ENG-CDR20004-R4-Response.pdf Markup Summary

GEC6

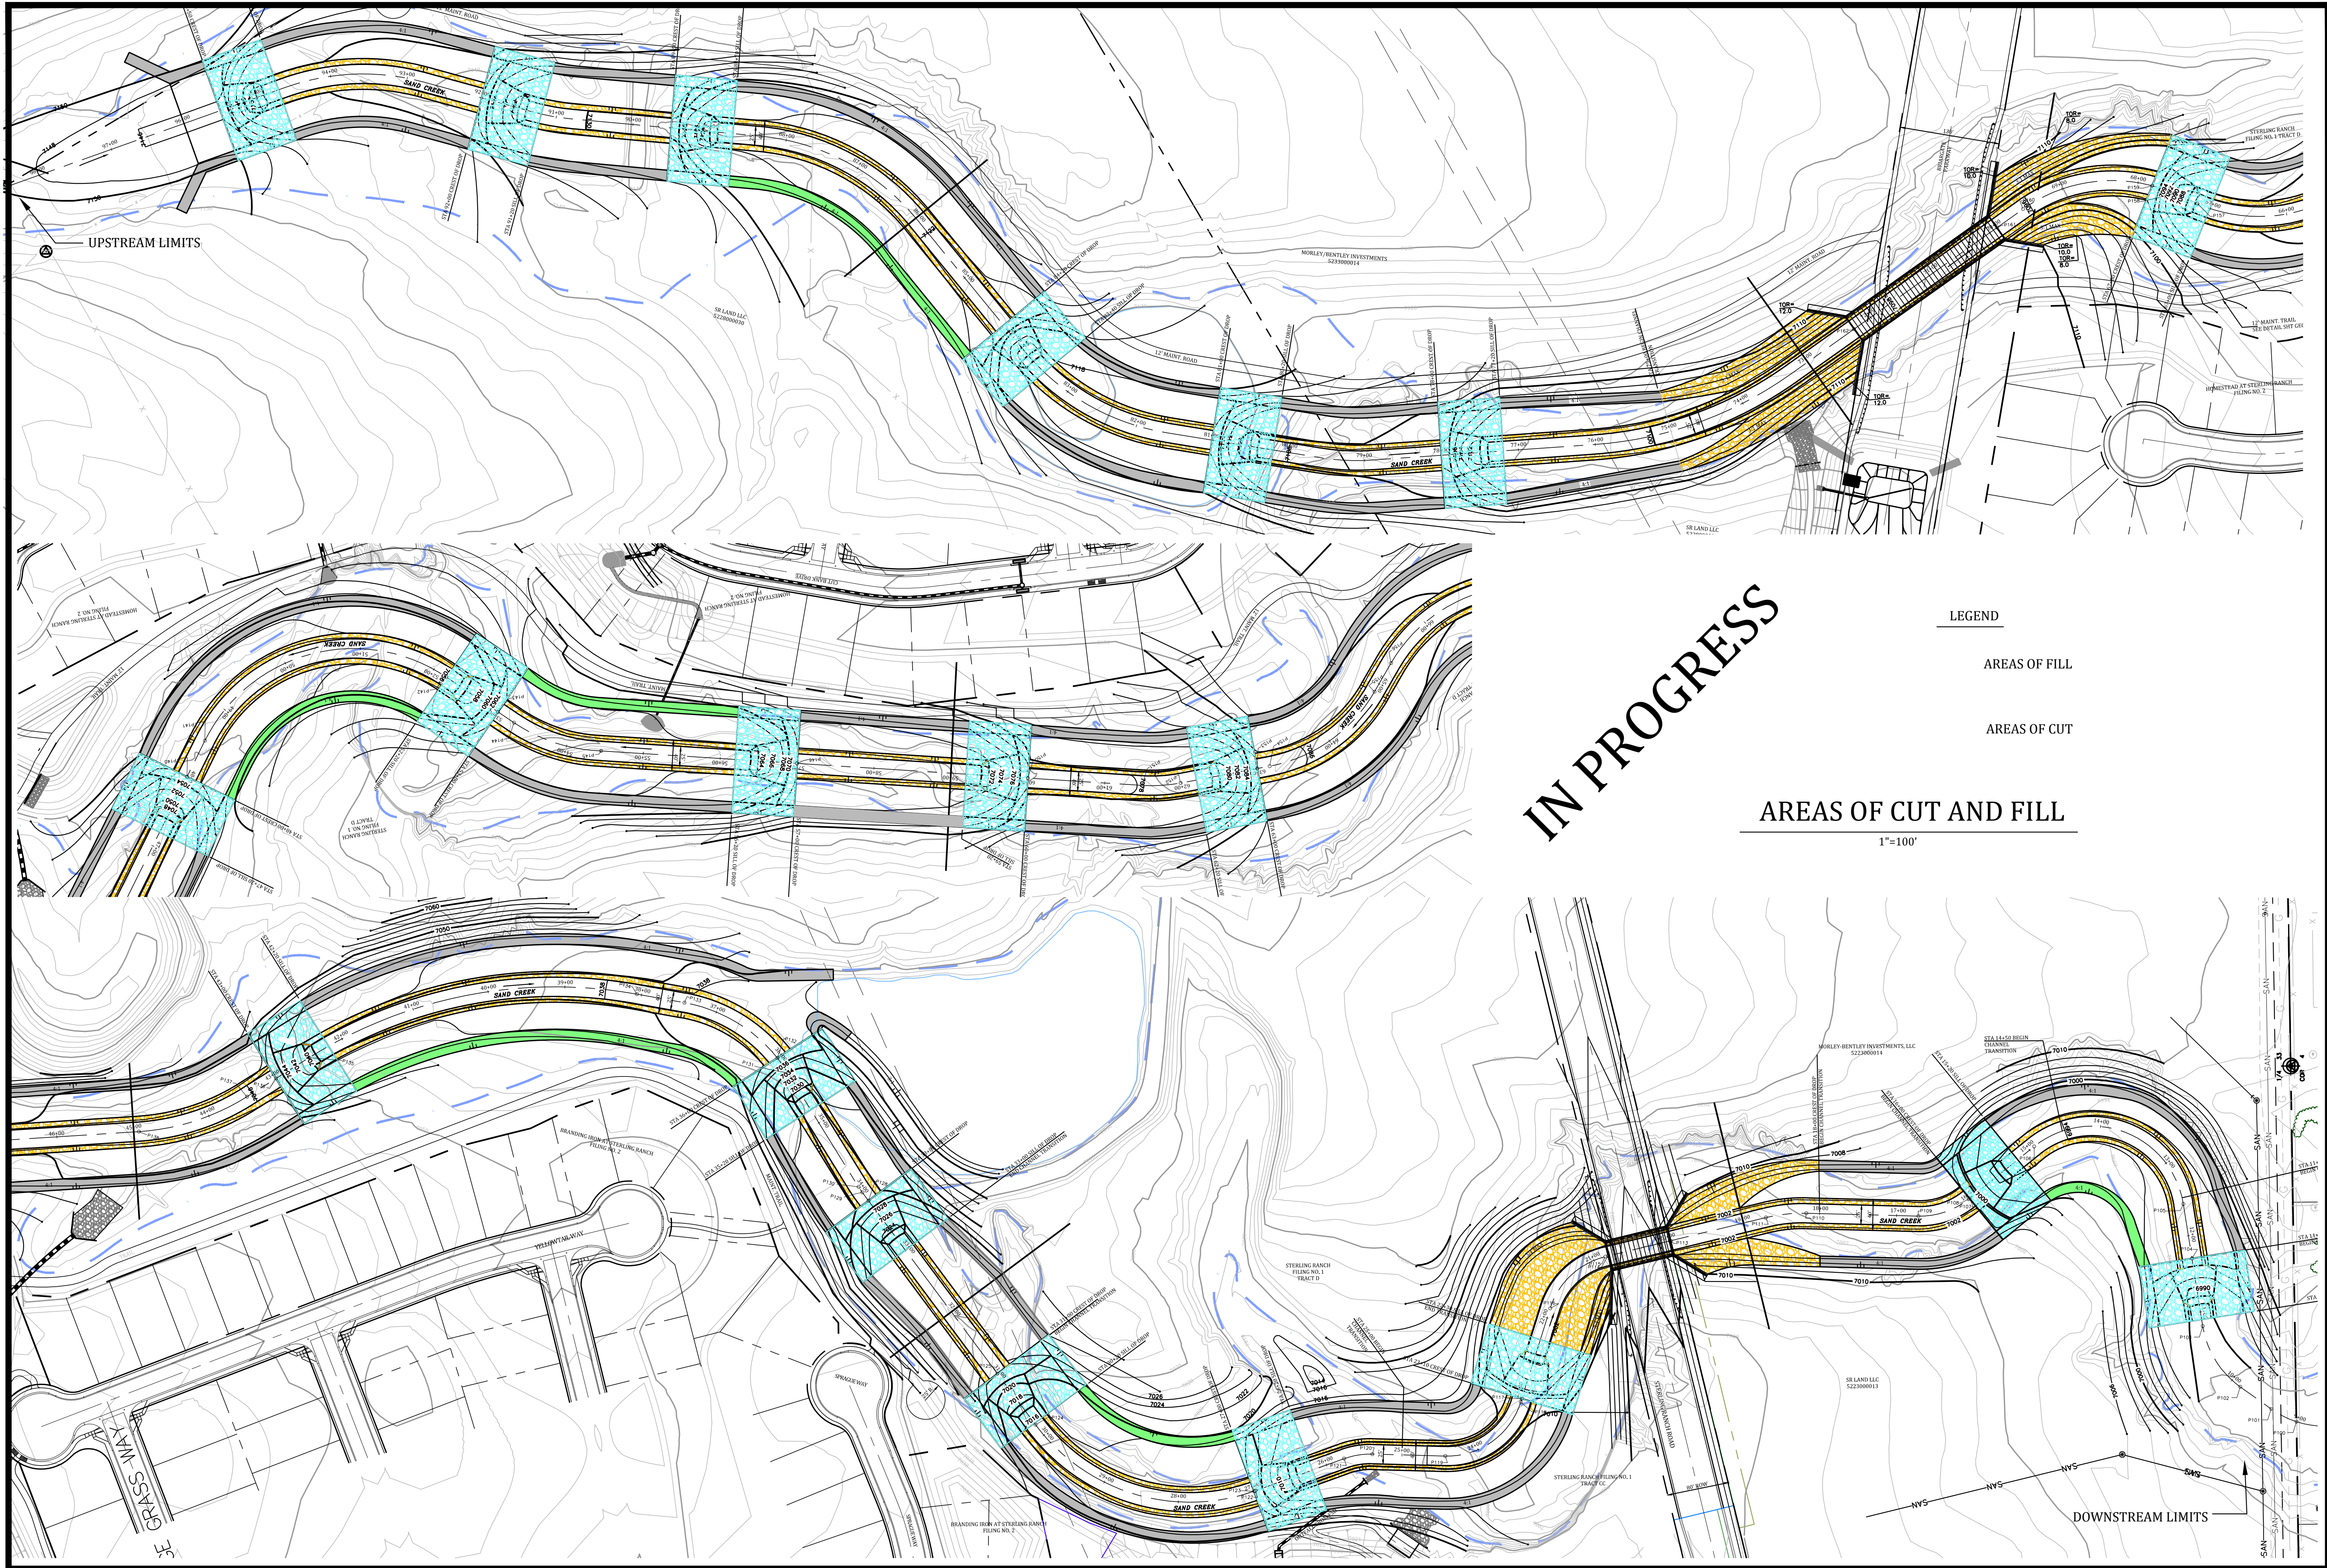
Subject:
Page Index: 5
Date: 5/18/2022 4:03:53 PM
Author: dsdrice
Color: ■
Layer:
Space:
Page Label: 5

cut/fill plan
